**Our Ref: BR/63/18/PL**

**Development** First & second Floor rear extension to create 3 No. studio apartments  
**Location** 77 Aldwick Road Bognor Regis

Drawing
EXISTING & PROPOSED
CYCLE & BIN STORES

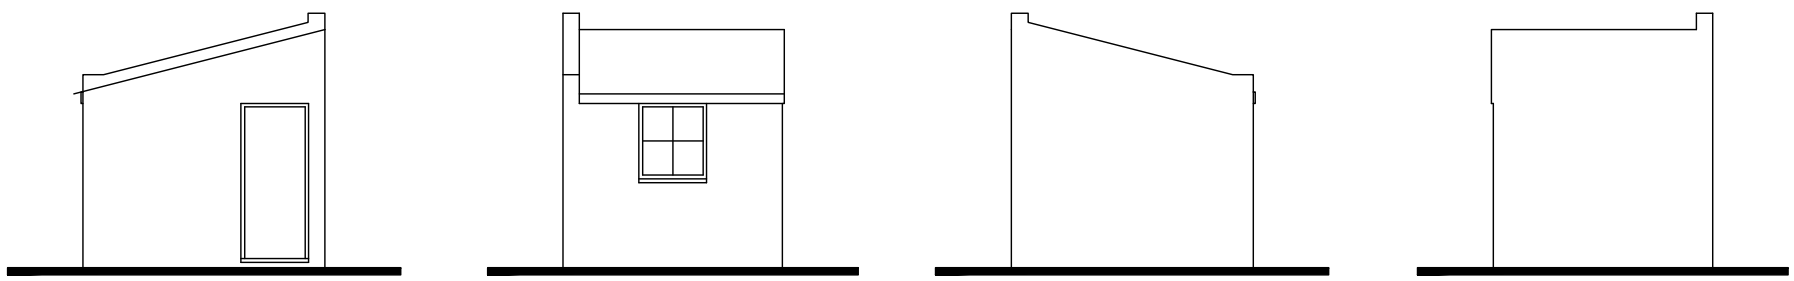
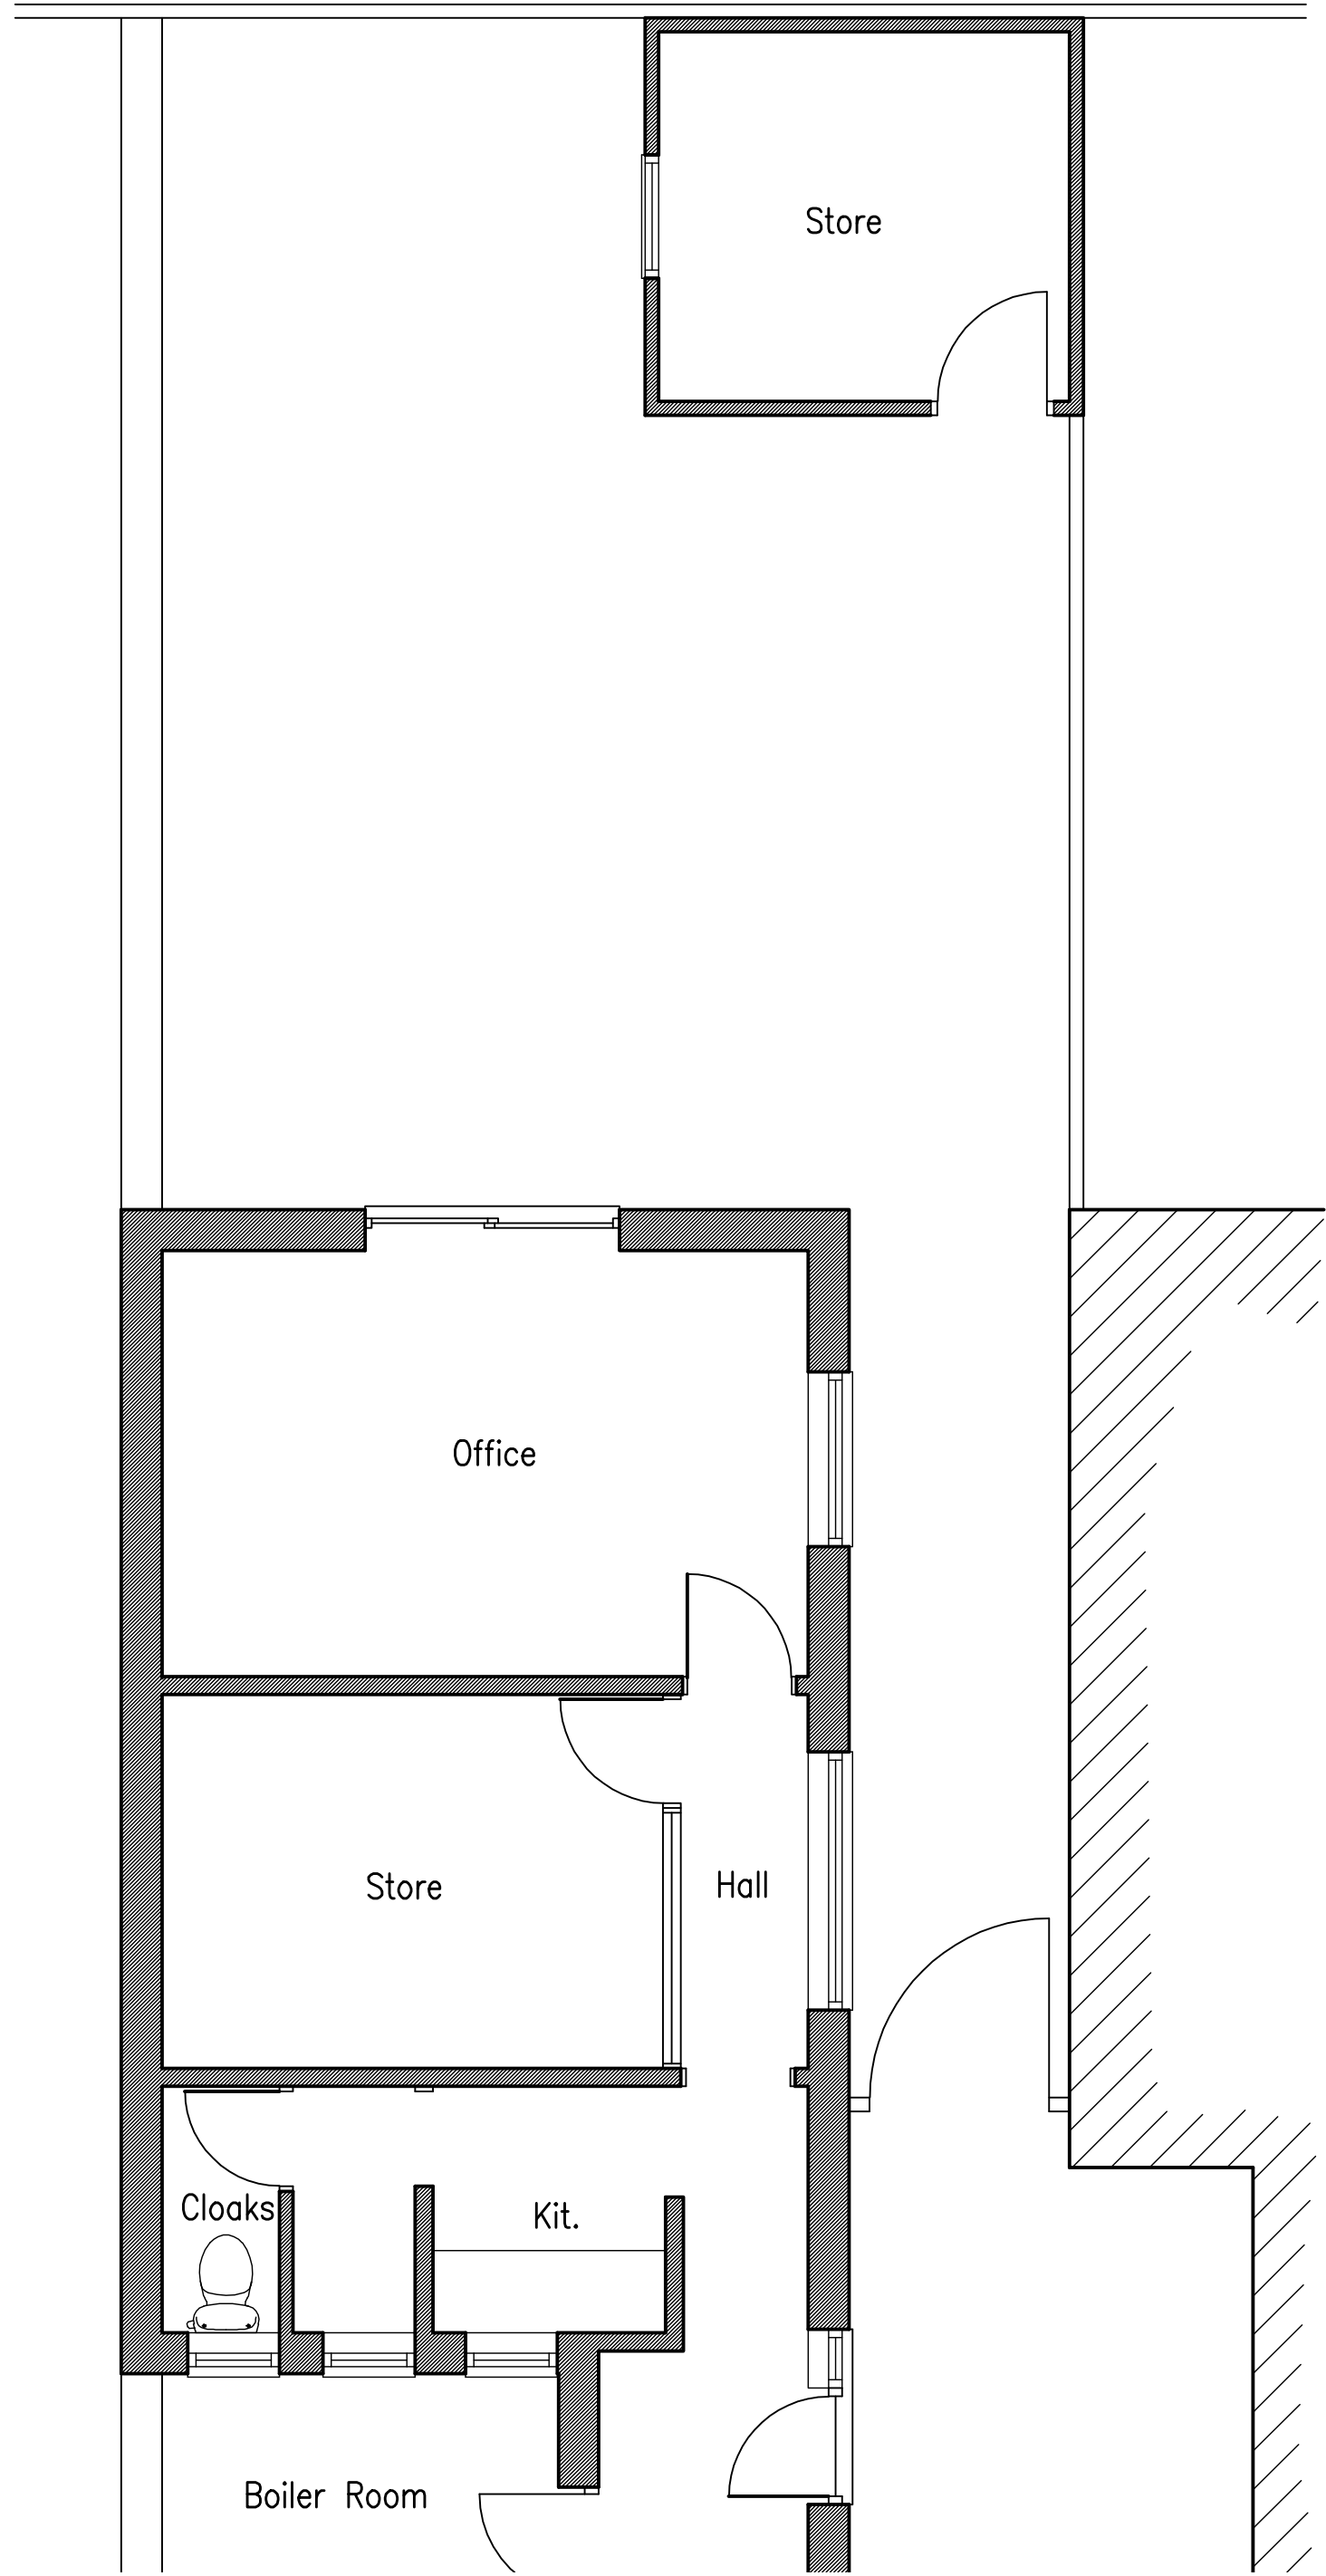
Please provide an elevation of the proposed new gate.

**GROUND FLOOR
EXISTING FLOOR PLANS**

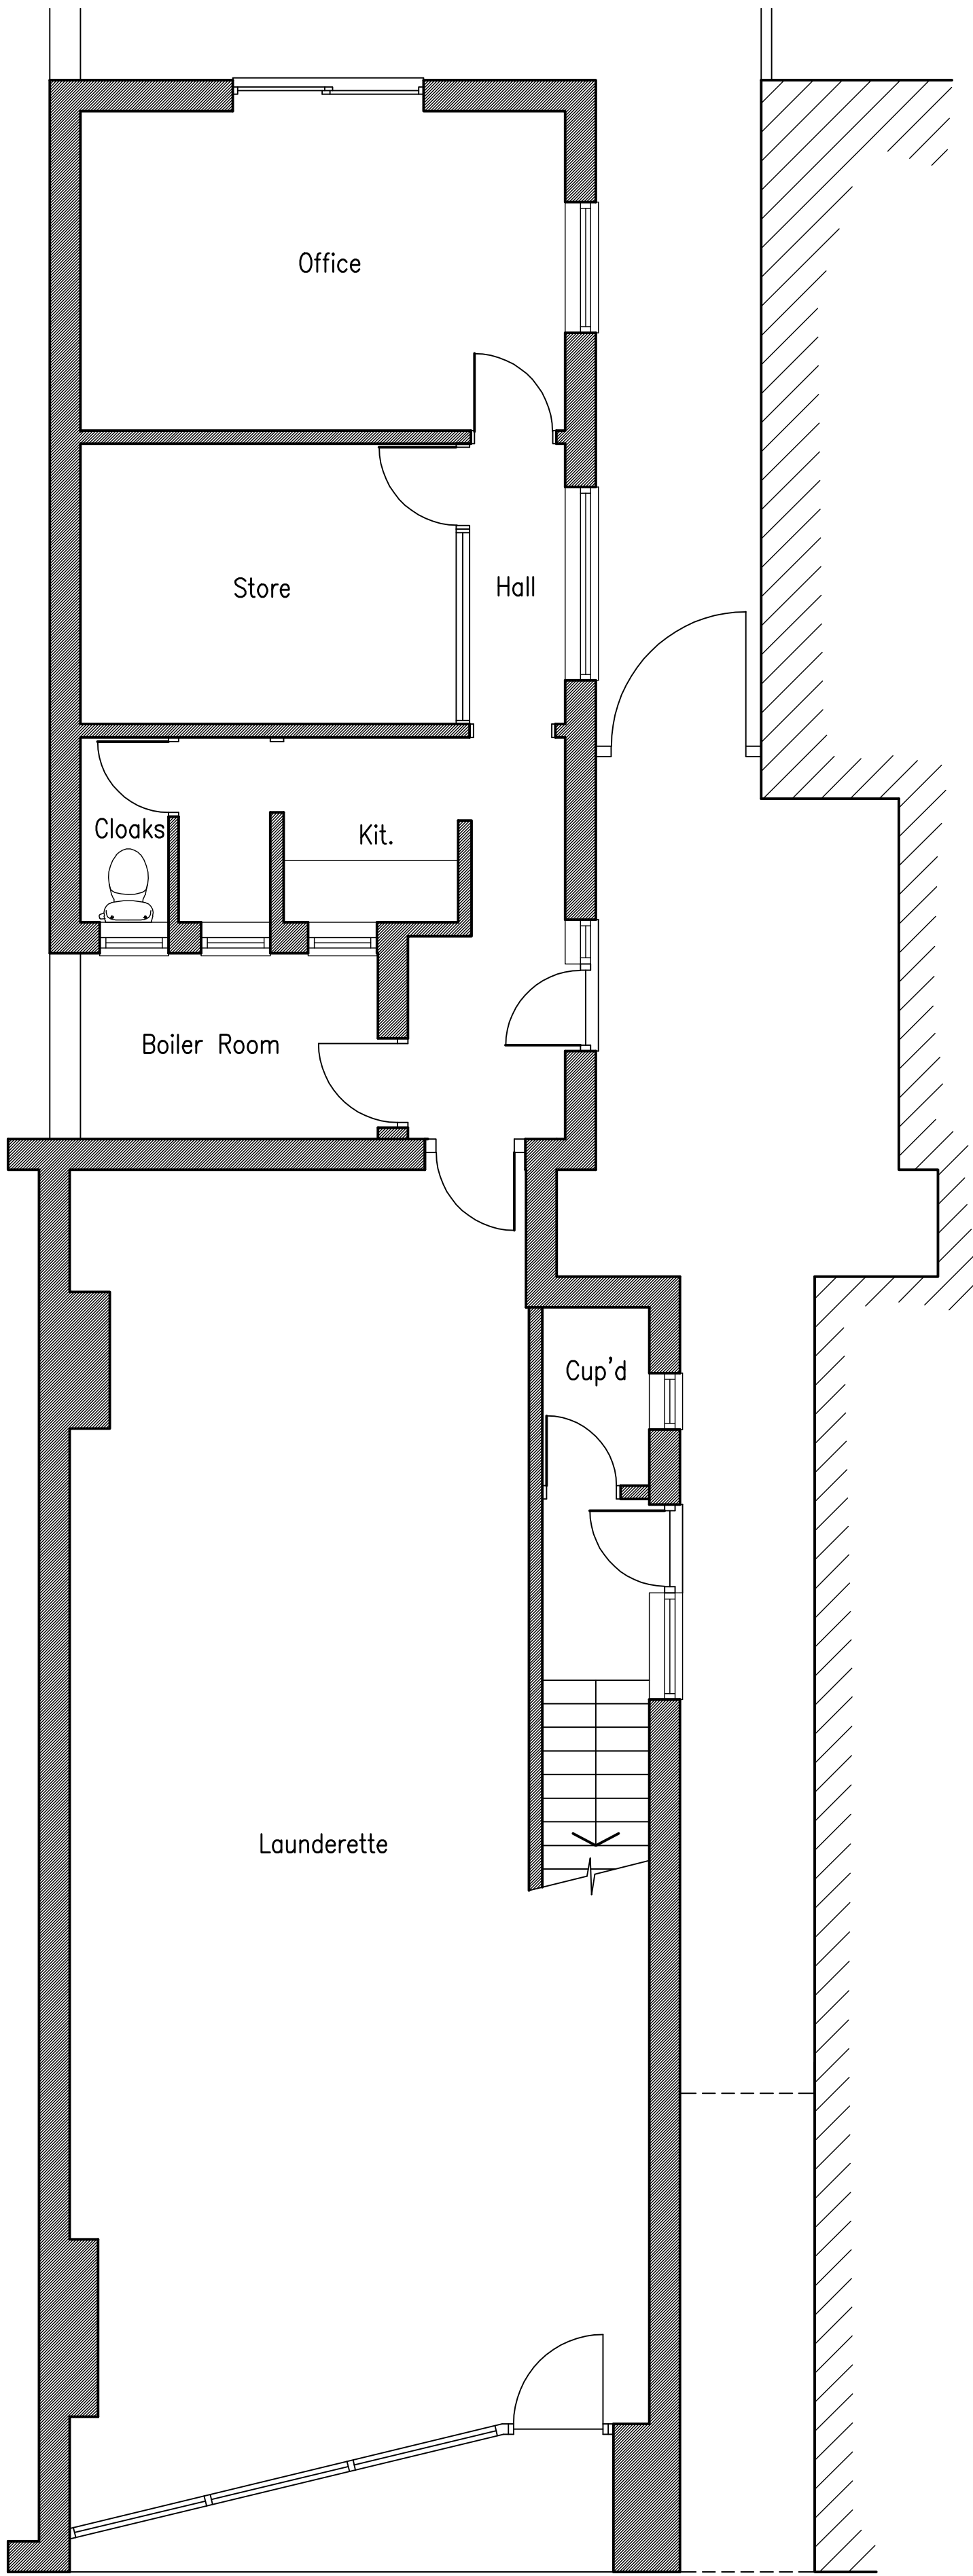
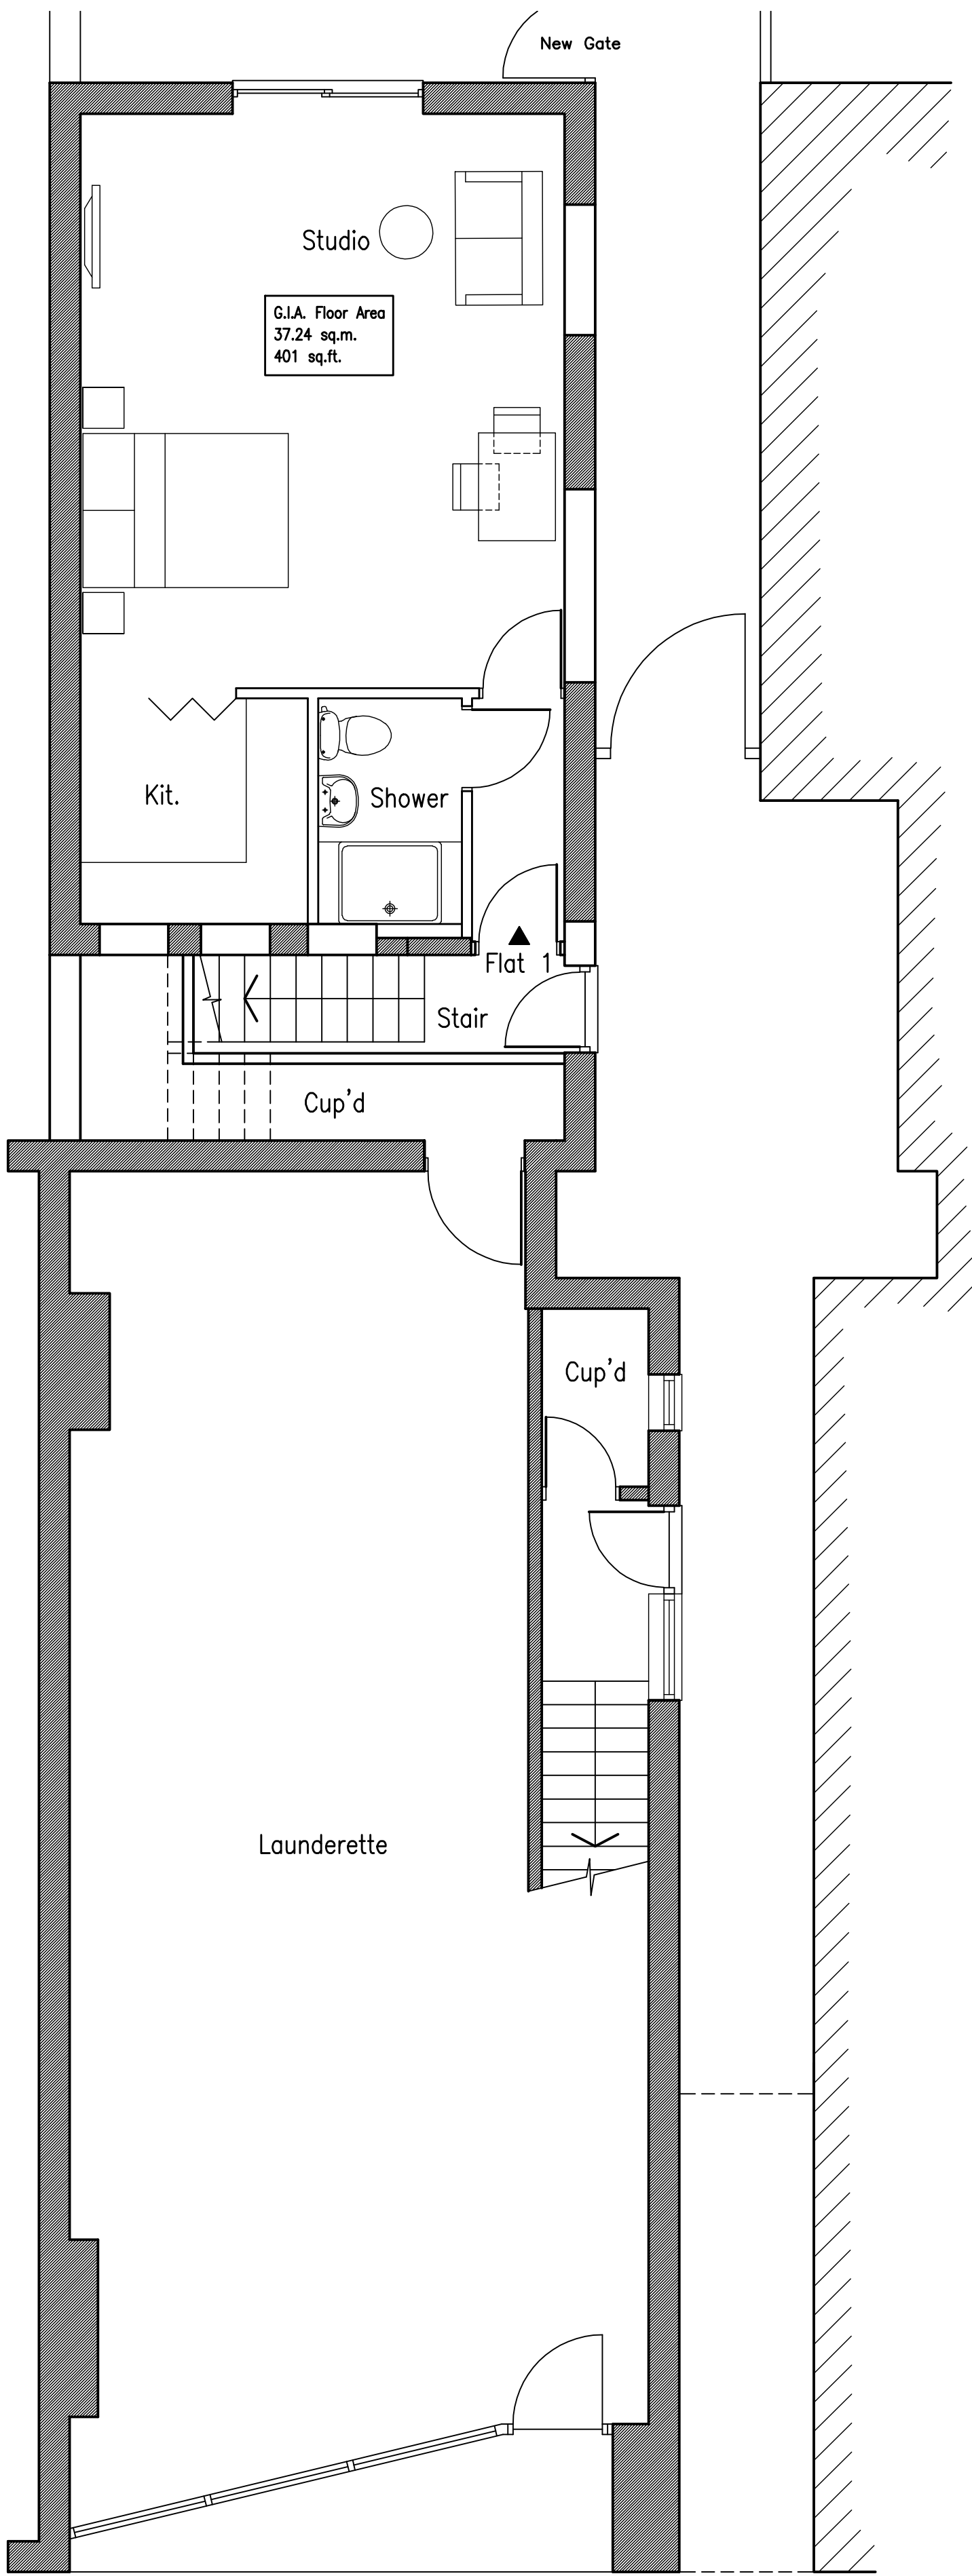
The existing and proposed ground floor plans and side elevations do not accord. Please amend accordingly.
